**Section 96A of the Town & Country Planning Act 1990 (as amended)
Town and Country Planning (Development Management Procedure) (England) Order 2015
(as amended) - Article 10**

Non-material amendment following grant of BR/147/20/PL to extend the depth of the building to meet the boundary wall and remove the small open space that was detailed in previous plans, removal of a ground floor window and reduction in size of the first floor window.

53 High Street Bognor Regis PO21 1RX

Drawing
Proposed Ground and First Floor Plans

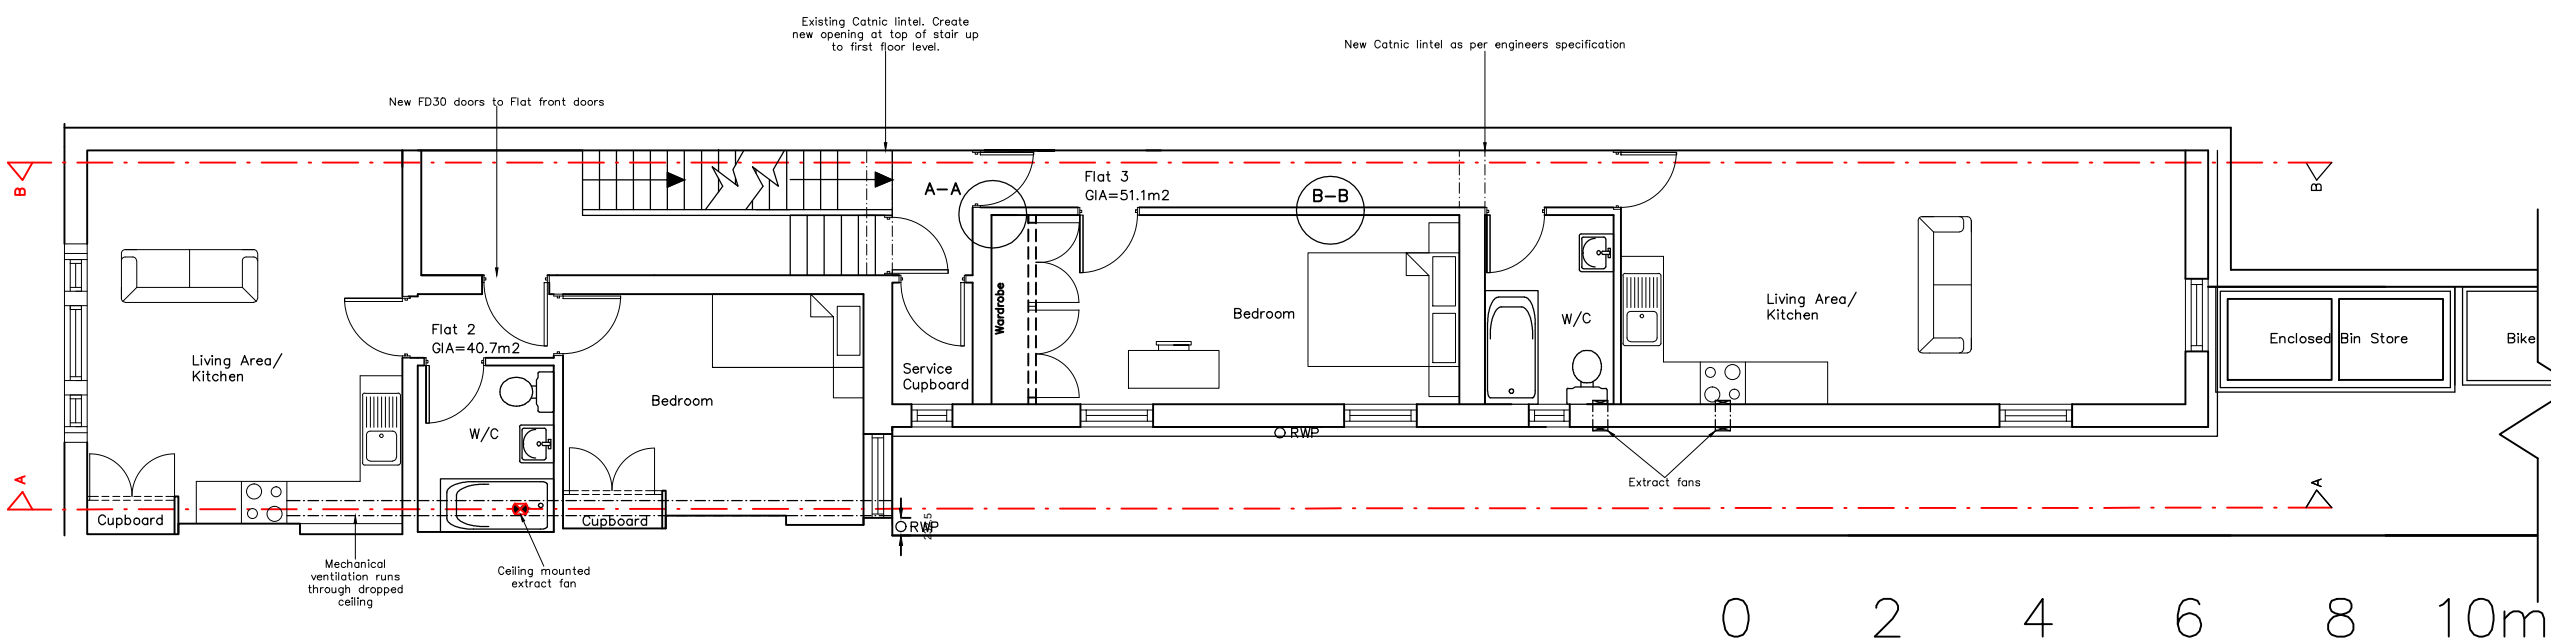
The reasons that these proposal has been accepted as Non-Material Amendments is because the changes do not materially alter the planning permission, do not necessitate additional consultation with local residents, do not breach planning policy and do not result in an increase in width/length by more than 1.0 metre. It is accepted that the building extended to the rear by 0.7m at the ground and first floor level. The proposed ground floor window of the extended wall would be removed and the first floor window would be reduced in size.

The proposed amendments would be minor, resulting in an increase of the length of approved building by 0.7m at both levels and reduction of fenestration. Therefore they can be considered as an NMA under section 96A of the Town and Country Planning Act 1990.

Please note that the drawing 04 Rev D replaces the originally approved the drawing 04 Rev B (Floor Plans), the drawing 05 Rev C replaces originally approved drawings 05 (Sections), the drawing 06 Rev D replaces originally approved drawing 06 Rev B (Front and Rear Elevations).
